From: Paul Cann
Sent: 24 August 2017 12:09
To: Planning.Responses
Subject: RE: Planning Consultation on: EG/59/17/HH

APPLICATION EG/59/17/HH

Site Address: 4 Wentworth Close Barnham PO22 0HS

Description of Works: Single storey rear extension

block plan
1 : 500

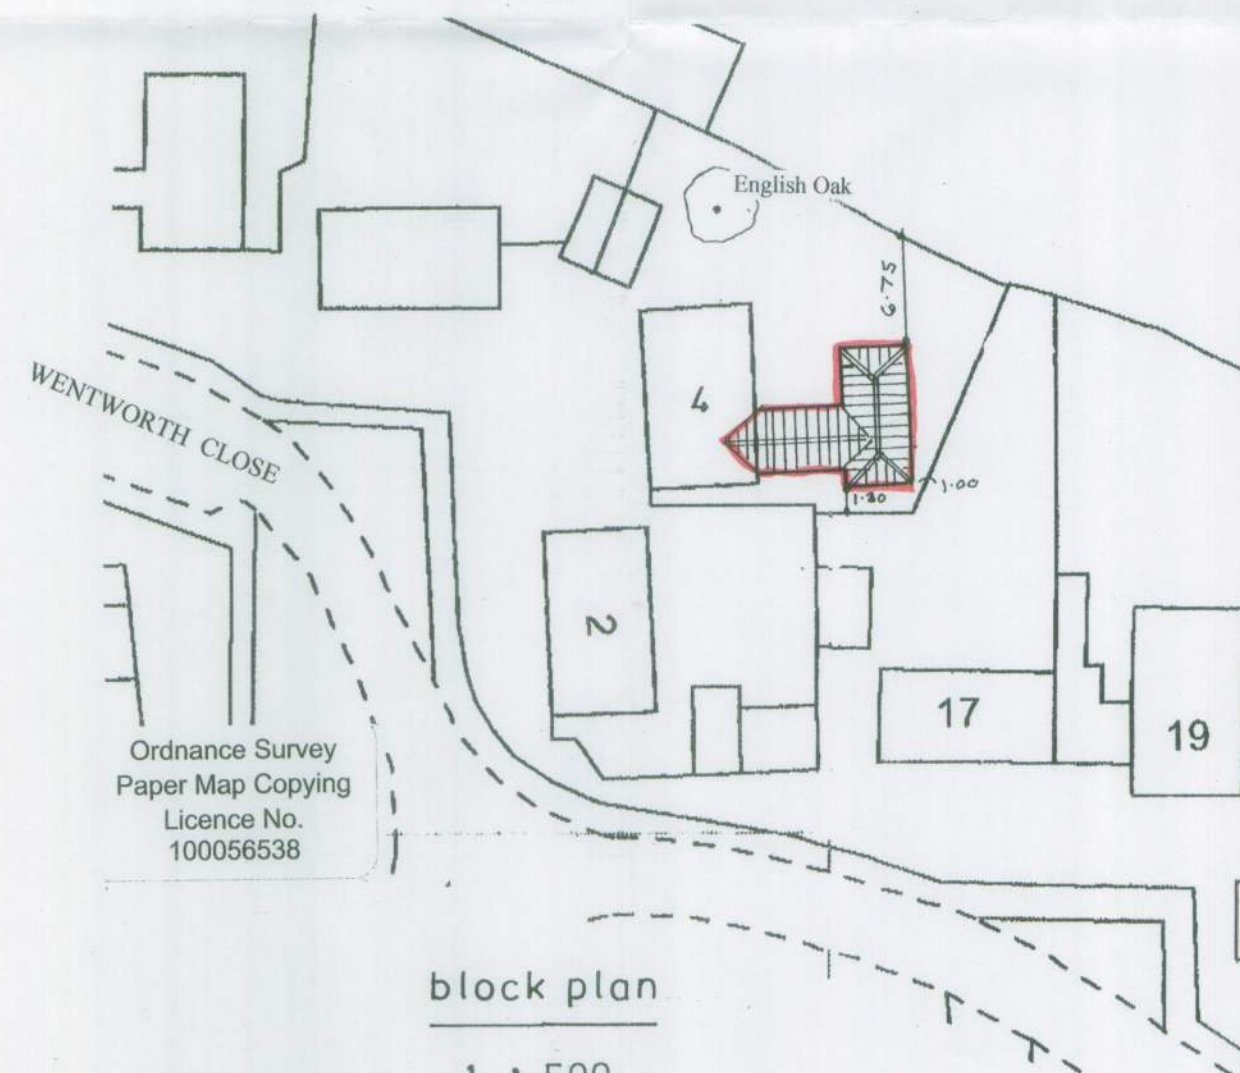
A culvert is believed to pass through the rear garden of the property. It is essential that its location/existence is confirmed by the applicant, so further discussion can be had. Any new building will need to be kept at least 3 metres from the edge of the culvert unless otherwise agreed.
